ARBORICULTURAL ASSESSMENT REPORT

Sydney Modern

02 August 2018

Prepared for
NSW Planning & Environment

## APPENDIX 4 - IMPACT ASSESSMENT SCHEDULE

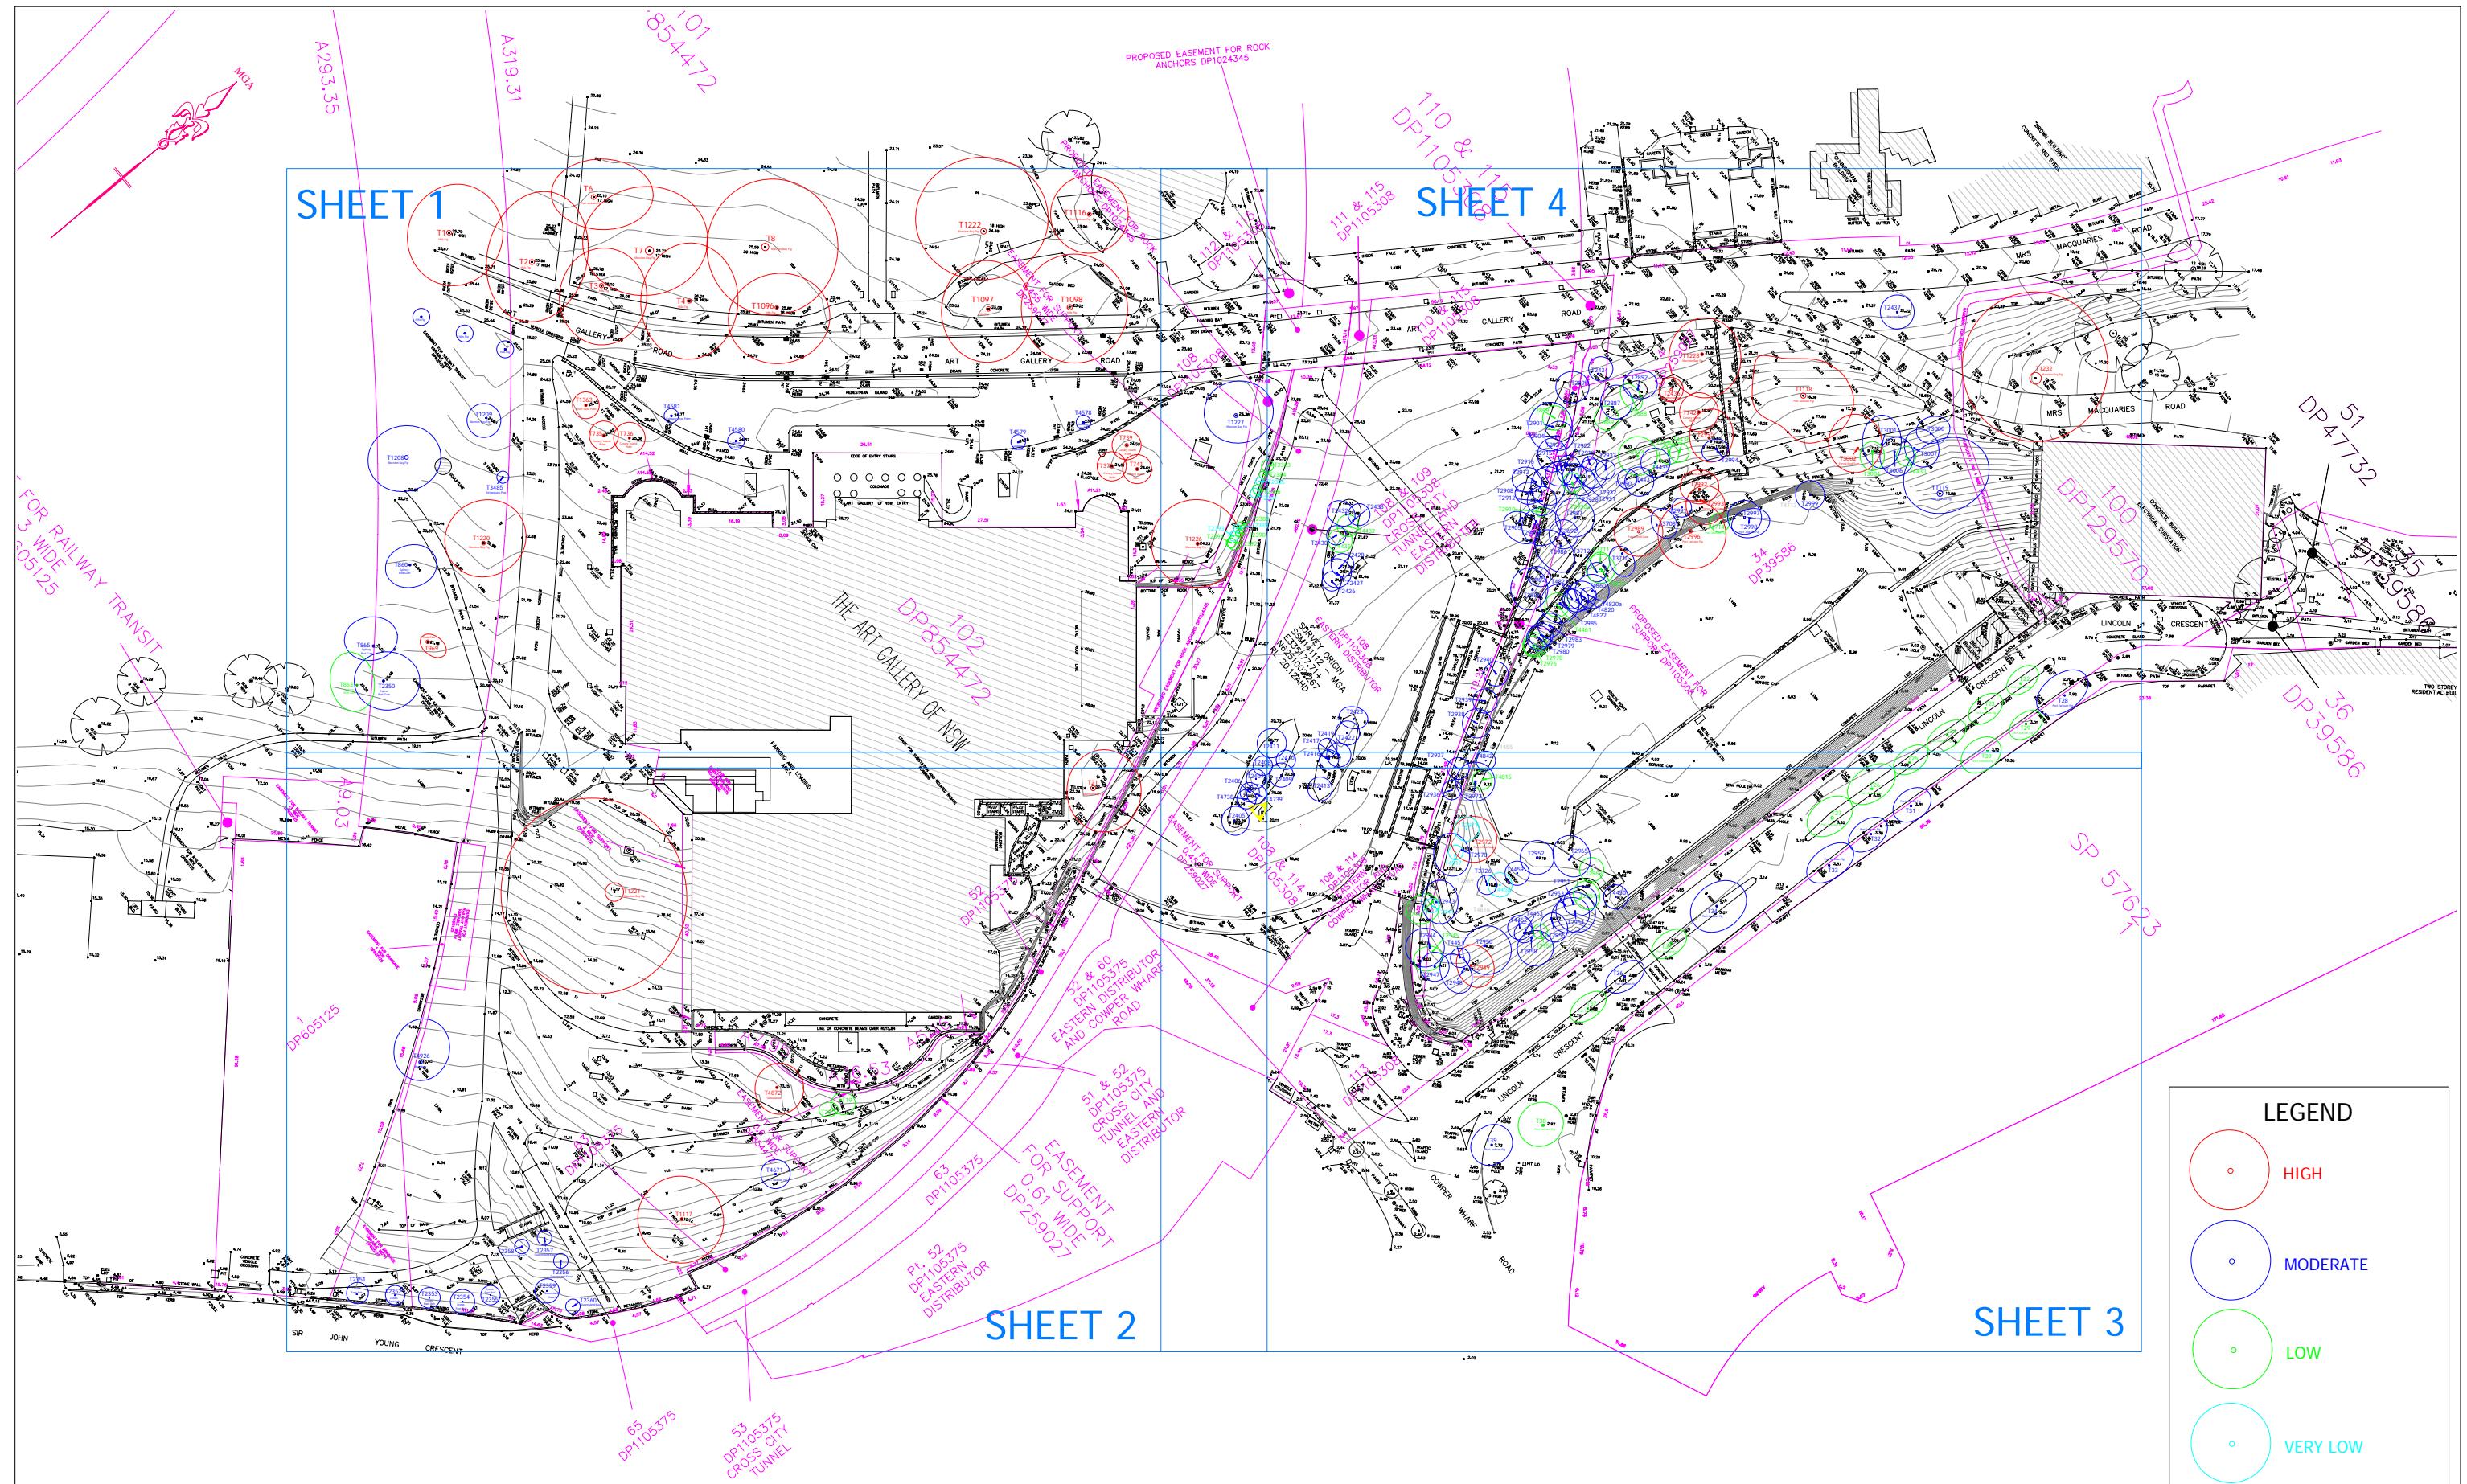
The TPZ of Trees 742, 2436, 2995 and 3002 are totally encroached by the proposed bulk earthworks and are not viable to be retained due to the proposed development.

The TPZ of Trees 1227, 1228, 4578, 4579, 4580 and 4581 are totally encroached by the proposed built form and are not viable to be retained due to the proposed development.

The TPZ of Trees 1118 and 2434 are have an overall encroachment that is a major encroachment and significantly greater than the minor encroachment defined by *AS4970-2009*. This extent of encroachment is likely to impact the health and condition of these trees and these trees are not viable to be retained due to the proposed development.

Trees 742, 1227, 1228, 1363, 2436, 4578, 4579, 4580 and 4581 are proposed to be transplanted. The Transplanting methodology and specification provided in Section 12 of Earthscape Horticultural Services Arboricultural Impact Assessment Report – Art Gallery of NSW Expansion Project – Sydney Modern dated 3 November 2018 represents industry best practice and will provide suitable conditions for the successful transplantation of the subject trees however as these trees are large, established trees, there is a residual risk that these trees may not be successfully transplanted. In order to further mitigate this risk this report nominates a number of risk mitigation factors in section 8.3.

Trees 1118 and 1126 are proposed to be retained. Tree 1126 is not encroached by the proposed development and remains viable to be retained. The total area of the TPZ encroachment of Tree 1118 is 45%. This is significantly greater than the 10% minor encroachment as defined by AS4970-2009. This extent of encroachment is likely to impact on the health and condition of this tree and therefore the viability of this tree to be retained within the landscape in-situ. This tree is currently in good health and condition with a dense canopy, minimal deadwood and minimal epicormic growth however it was noted that there is a significant amount of apical dieback evenly spread over the entire canopy which is indicative of stress on this tree. This will further impact upon the viability of this tree to be retained in-situ.

In order to further investigate the total encroachment proposed for Tree 1118, we recommend further investigation of the root plate of this tree by means of root mapping. Root mapping may be carried out using Ground Penetrating Radar (GPR) or by non-destructive excavation using an Air Knife. Please note that vacuum trucks or high pressure water are not suitable. Further investigation to be made into the proposed shoring methods to accurately determine the extent of excavation required for shoring.
